The Planning
Inspectorate

SCOPING OPINION

Proposed Seabank 3 CCGT

March 2013

Figure 2: Potential DCO Boundary

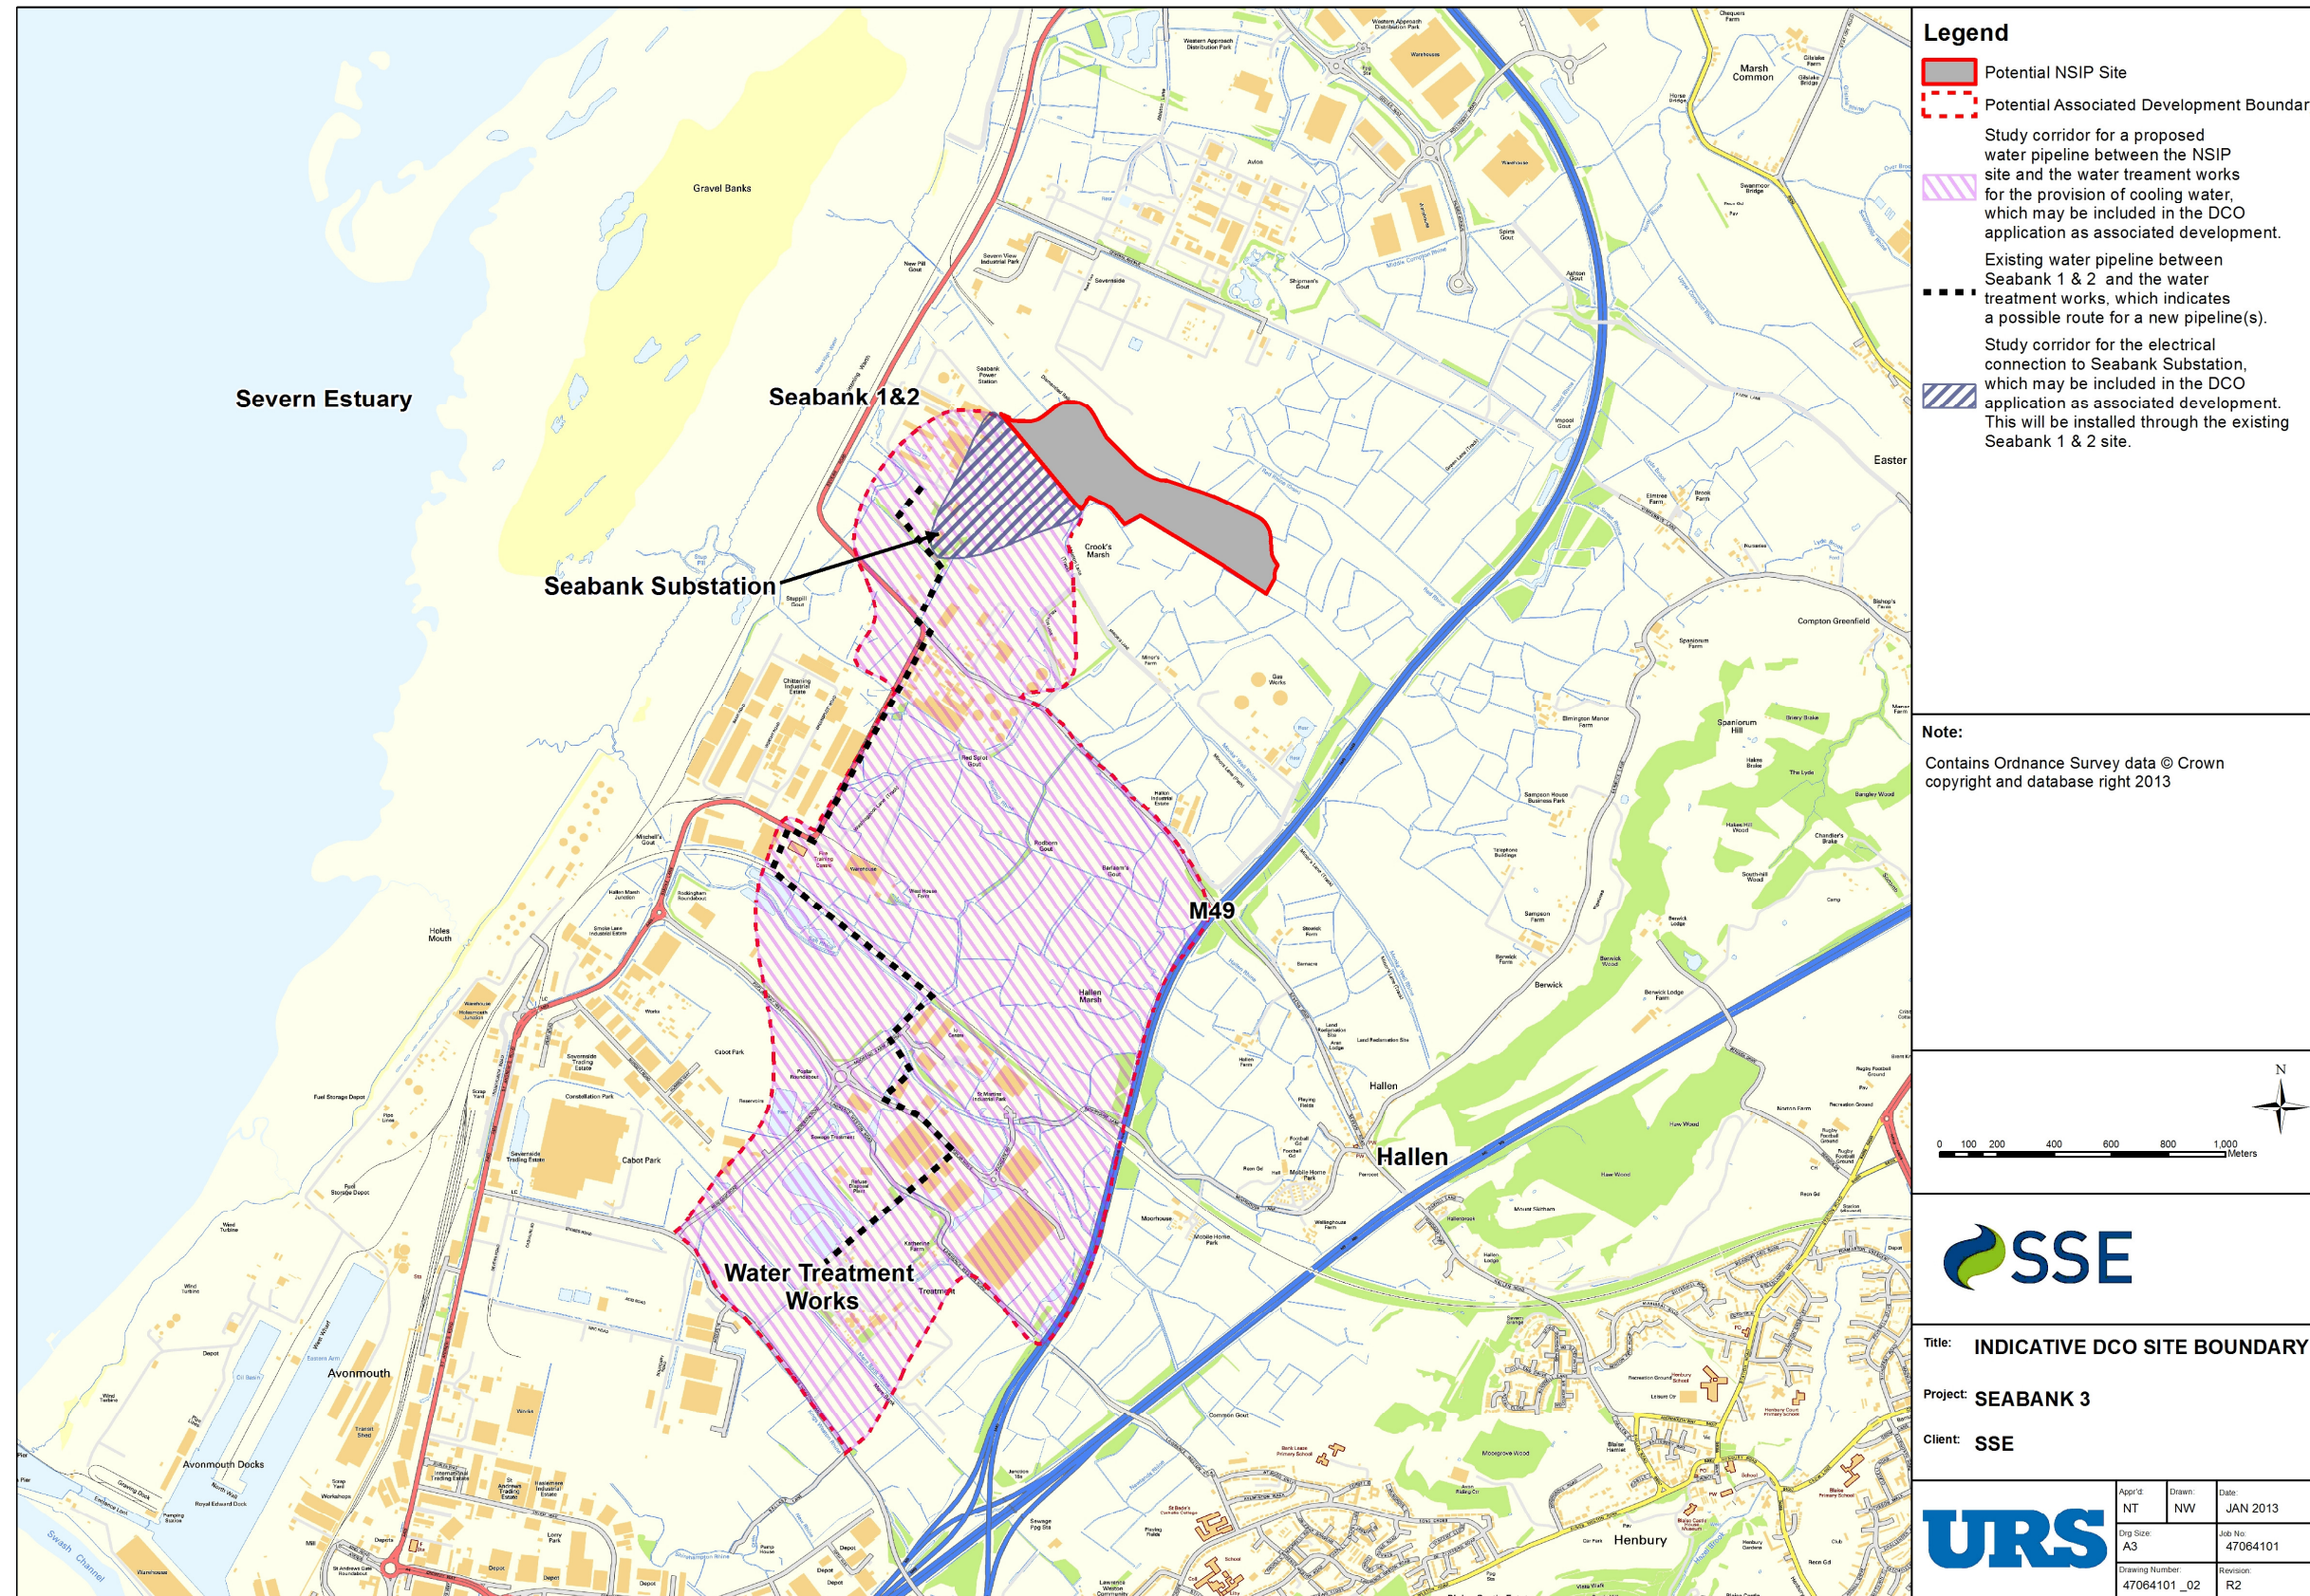
- 2.34 The Description of the Site in Section 2 of the Scoping Report is focused on the land identified as the Potential NSIP Site in Figure 2 of the Scoping Report (Potential DCO Boundary). This is where the main CCGT plant and reserved area for CCS technology is proposed. Limited information is provided on the following land areas falling within the Potential Associated Development Boundary shown in Figure 2:

- 2.36 References in the Scoping Report to the areas shown on Figure 2 are inconsistent. For example, the legend in Figure 2 refers to the 'Potential NSIP Site', whereas Figure 8 refers to the same area as the 'NSIP site boundary' and Figure 9 to the 'Potential Site Boundary'. To avoid confusion care should be taken in preparing the ES to ensure that the Application Site is clearly and consistently defined. All elements of the proposed development including location should be clearly and correctly identified in the text and on accompanying figures and plans.

- Study corridor for the electrical connection to Seabank Substation, which may be included in the DCO application as associated development.
- 2.35 The Applicant should ensure that the description of the site and surroundings in the ES corresponds with the DCO application site boundary and includes a description of the aspects of the environment likely to be significantly affected by the development, in accordance with the requirements set out in Schedule 4 Part 1 of the EIA Regulations 2009. The scope and methodologies of surveys necessary to provide this information should be agreed with relevant consultees.
